From: Liz Annalls [REDACTED]
Sent: 04 March 2020 11:32
To: Planning.Responses <Planning.Responses@arun.gov.uk>
Subject: RE: Planning Consultation on: LU/48/20/PL

App No: LU/48/20/PL

Address: Southdown Nursery Old Mead Road Littlehampton BN17 7PU

Proposal: Demolition of 1 No. bungalow & outbuildings & erection of 22 No. dwellings with associated parking & open space. This application is a Departure from the Development Plan.

Figure No. 01 - Site Habitat Plan
Thornlea Park, Old Mead Road, Wick, West Sussex

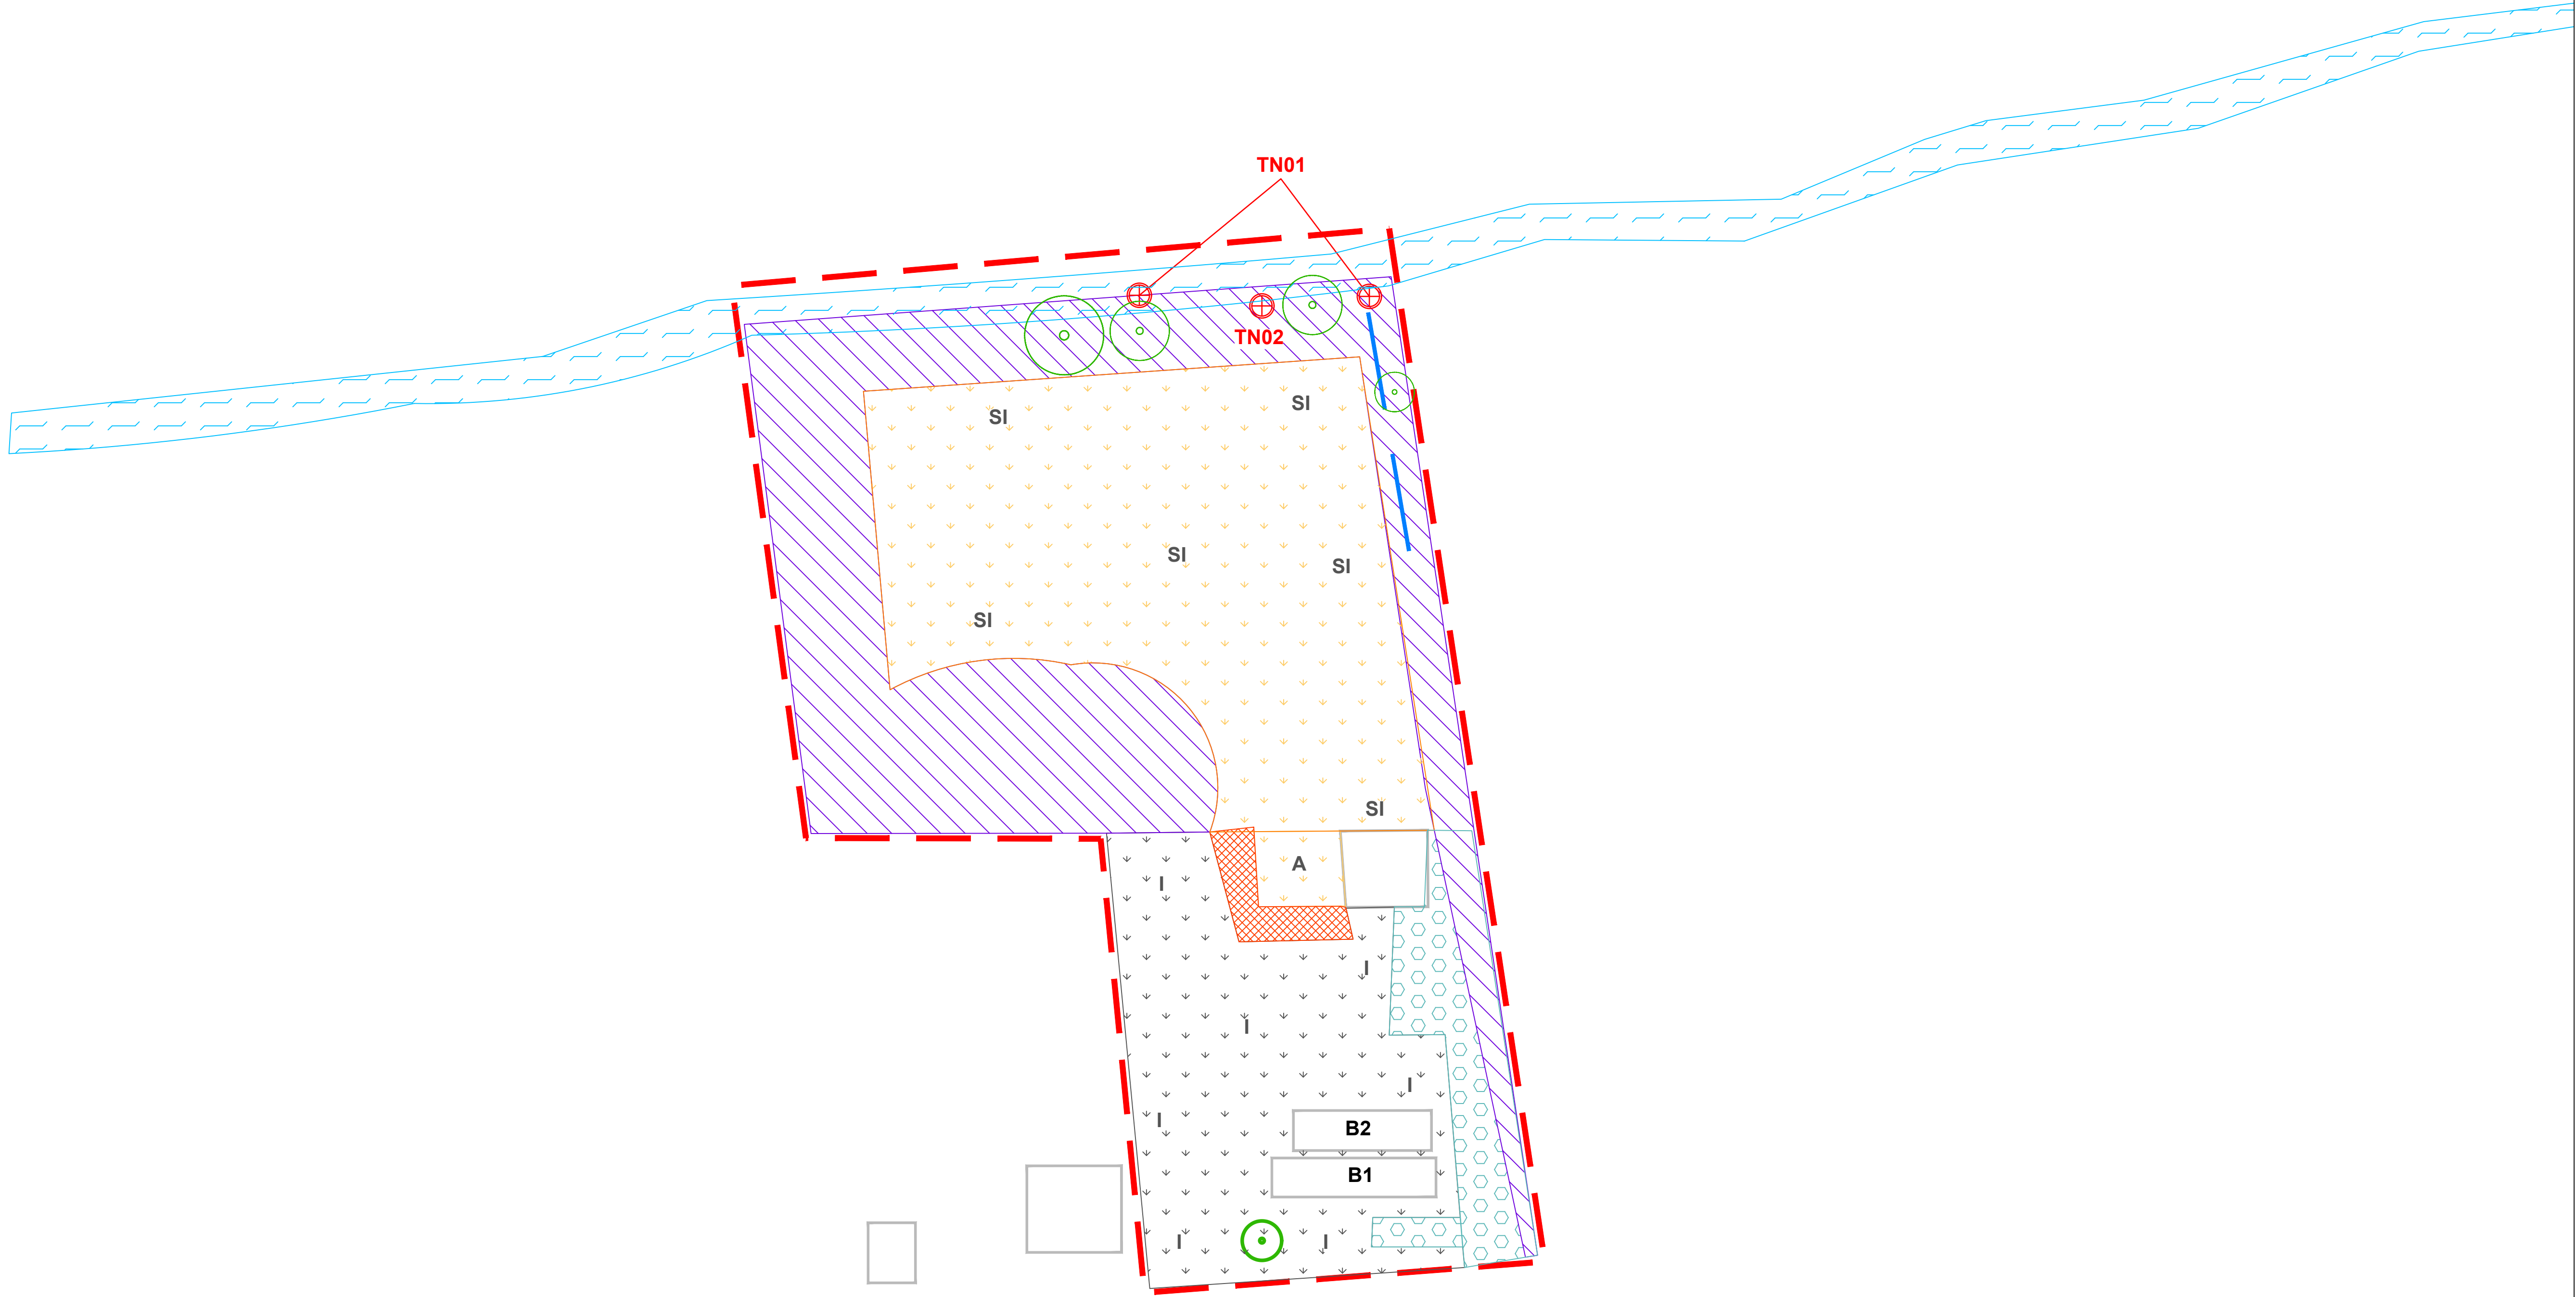
The hedgerows on site are used by bats for commuting and foraging and will need to be retained and enhanced for bats. This will include having a buffer strip around the hedgerows (5m) and during construction fencing should be used to ensure this area is undisturbed. Any gaps should also be filled in using native hedge species to improve connectivity. Conditions should be used to ensure this.

Due to the presence of water voles within the ditch on the eastern section of the site no works can take place within this ditch or area and a 5m buffer should be set up from the ditch bank and fencing used during the construction period to ensure this area remains undisturbed.

If any works need to take place in this area, then full water voles surveys and a mitigation strategy for water voles will be required.
